Recommendation Report for Planning Permission for Works or Extension to a Dwelling

REF NO: BR/342/19/HH

LOCATION: 67 Ash Grove
Bognor Regis
PO22 9JT

PROPOSAL: Creation of new steps and handrail for disabled access to front door.

Drawing Title  
Proposed Front Access

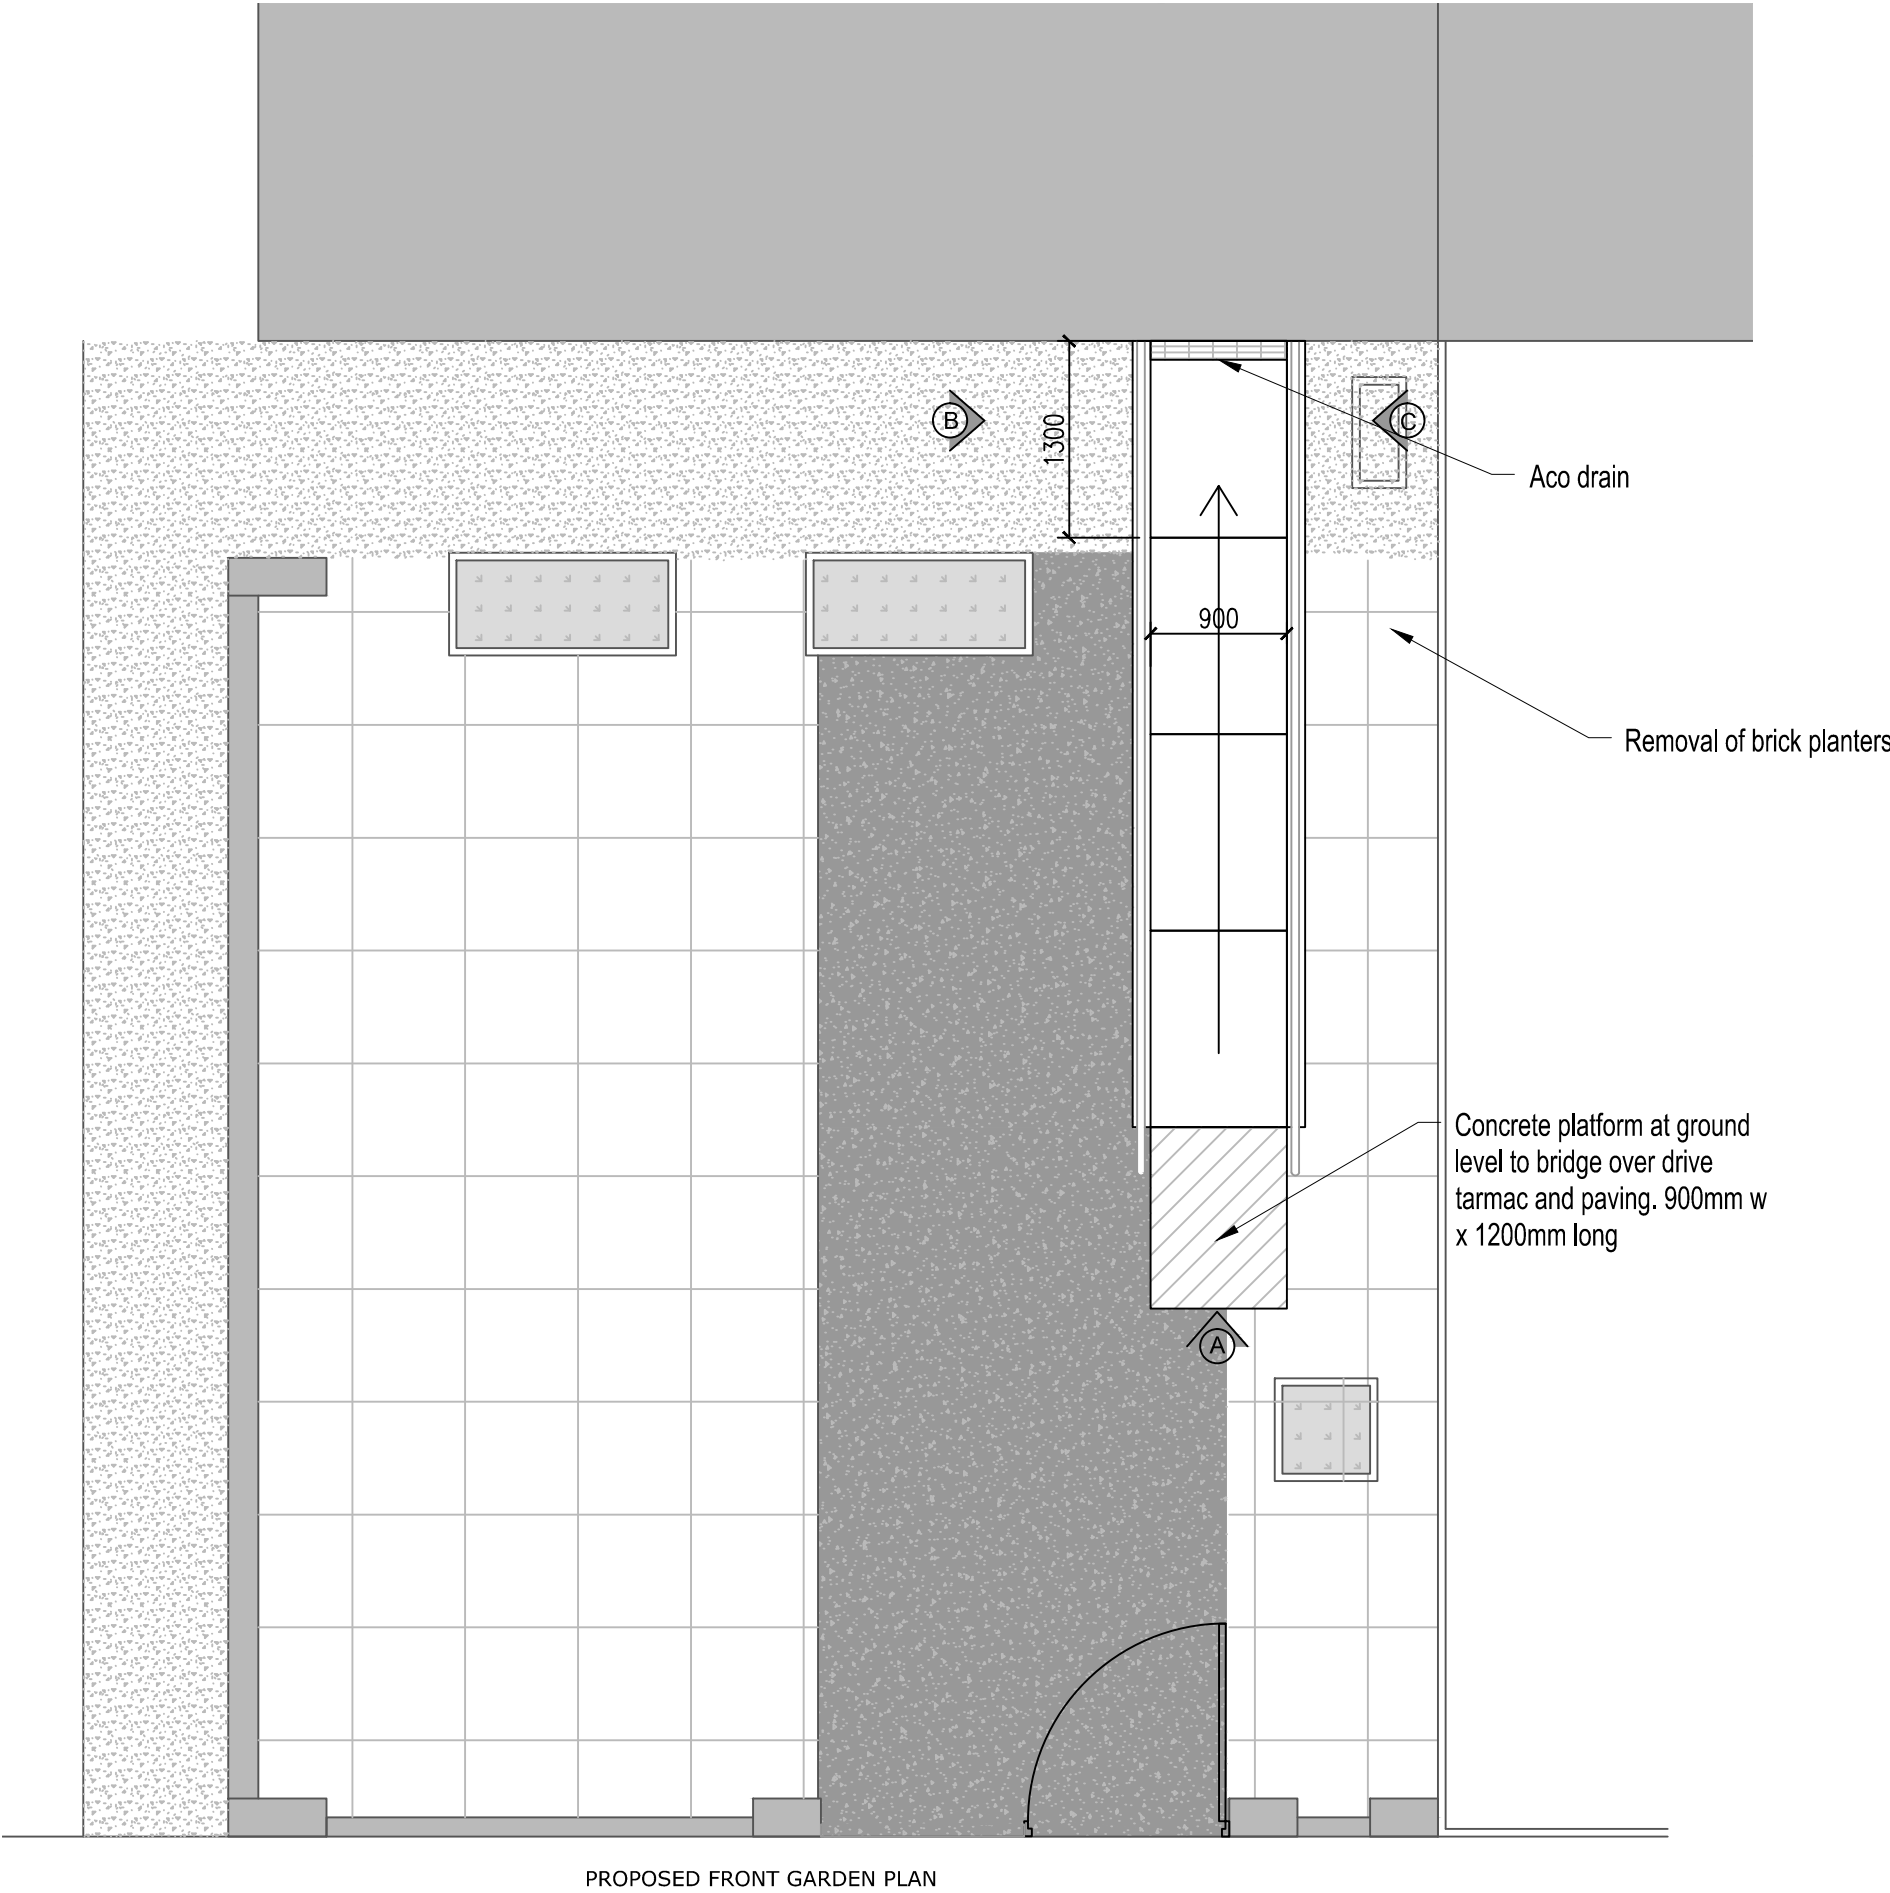
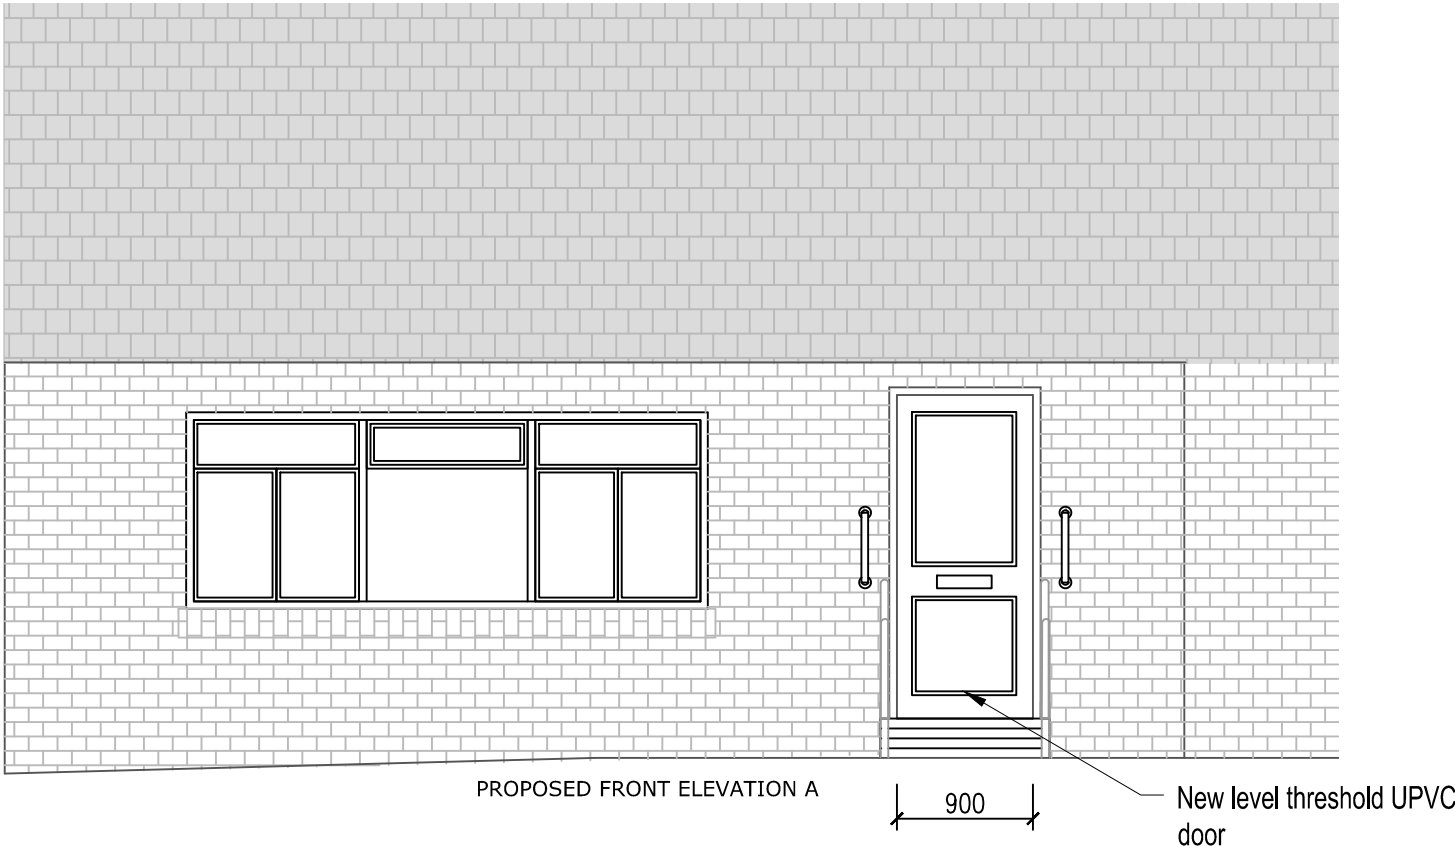
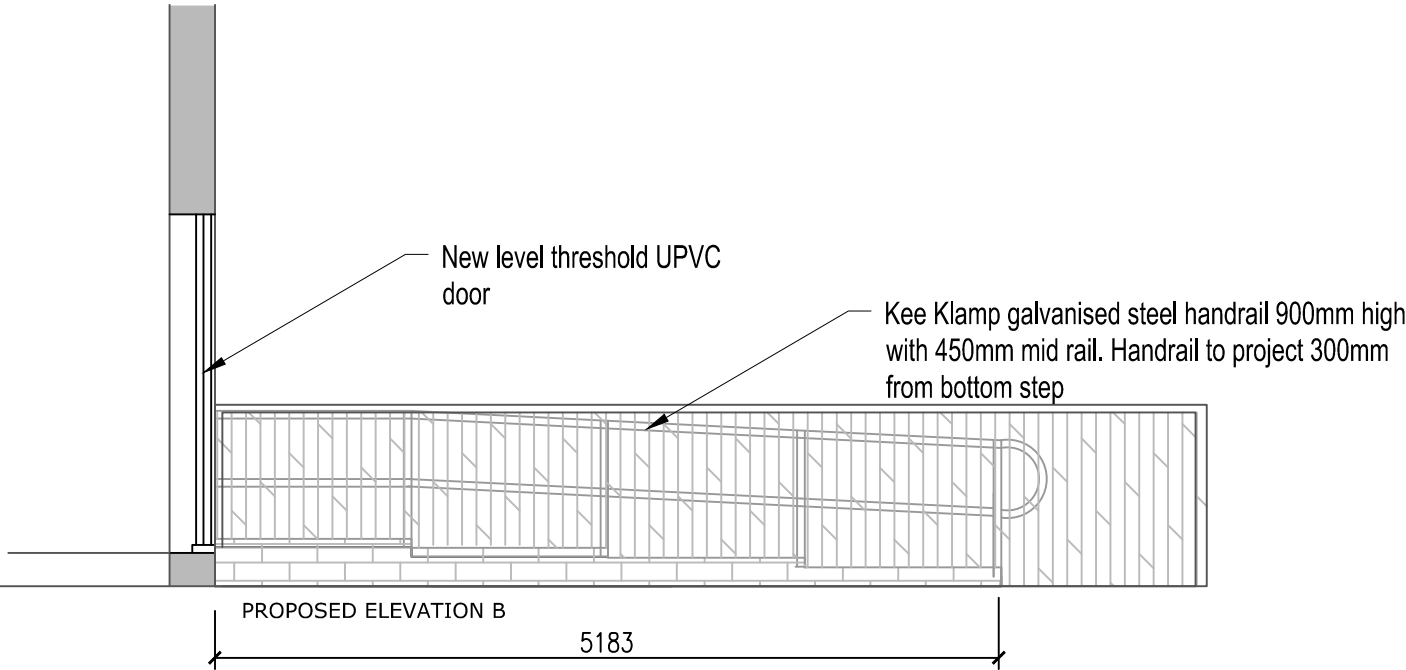
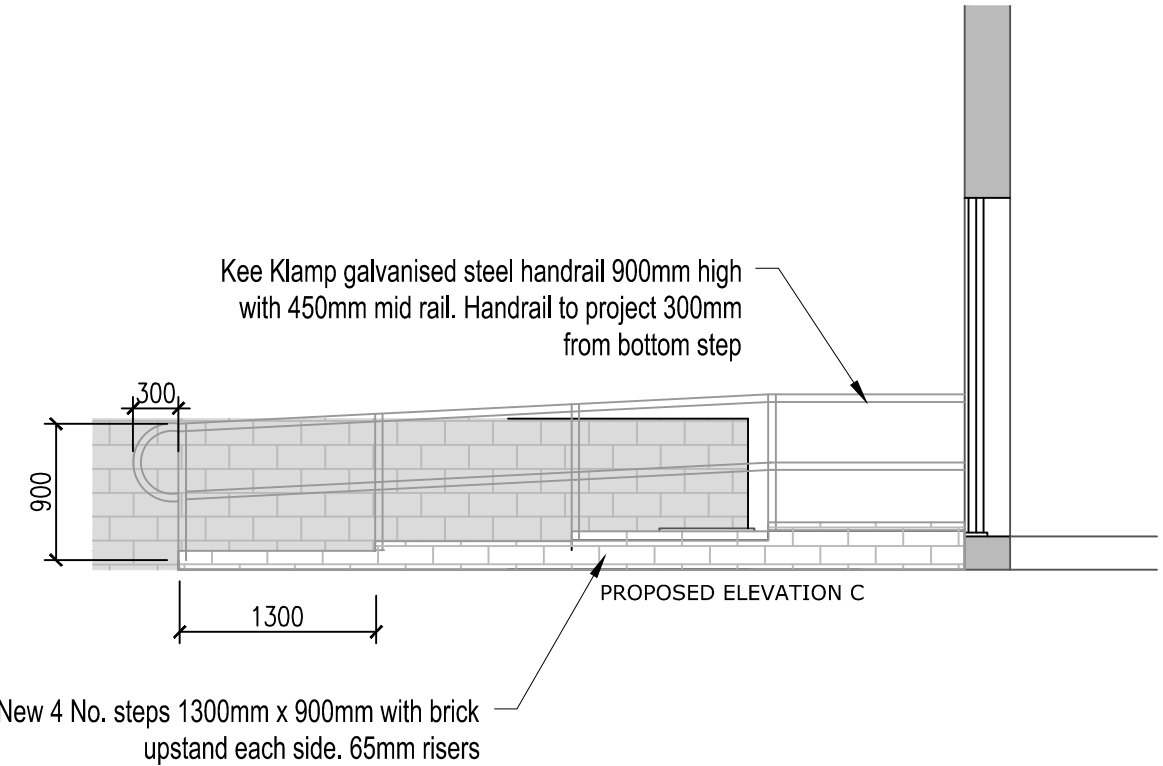
The development will consist of 4 steps. These will each be 1.3m in depth and 0.9m in width. The steps have a maximum height of 0.3m. There will be handrails running along the both sides of the steps with a height of 0.9m. Whilst the development extend quite far into the front garden with a total depth of 5.1m, 4m is retained to the front boundary of the property, and the steps and handrail at a low level height and set below just below that of the neighbouring fence.

Whilst the development will alter the appearance of the property, due to the modest height, it is not considered give rise to significant adverse affects on the spatial pattern or character of the area in which a refusal is justified. The development is deemed to accord with D DM1 and D DM4 of the Arun Local Plan.

Due to the type of development proposed and the siting which extends beyond the principal elevation, it is not considered to harm neighbouring amenity by way of overbearing, overshadowing or overlooking and accord with D DM1 and D DM4 of the Arun Local Plan.
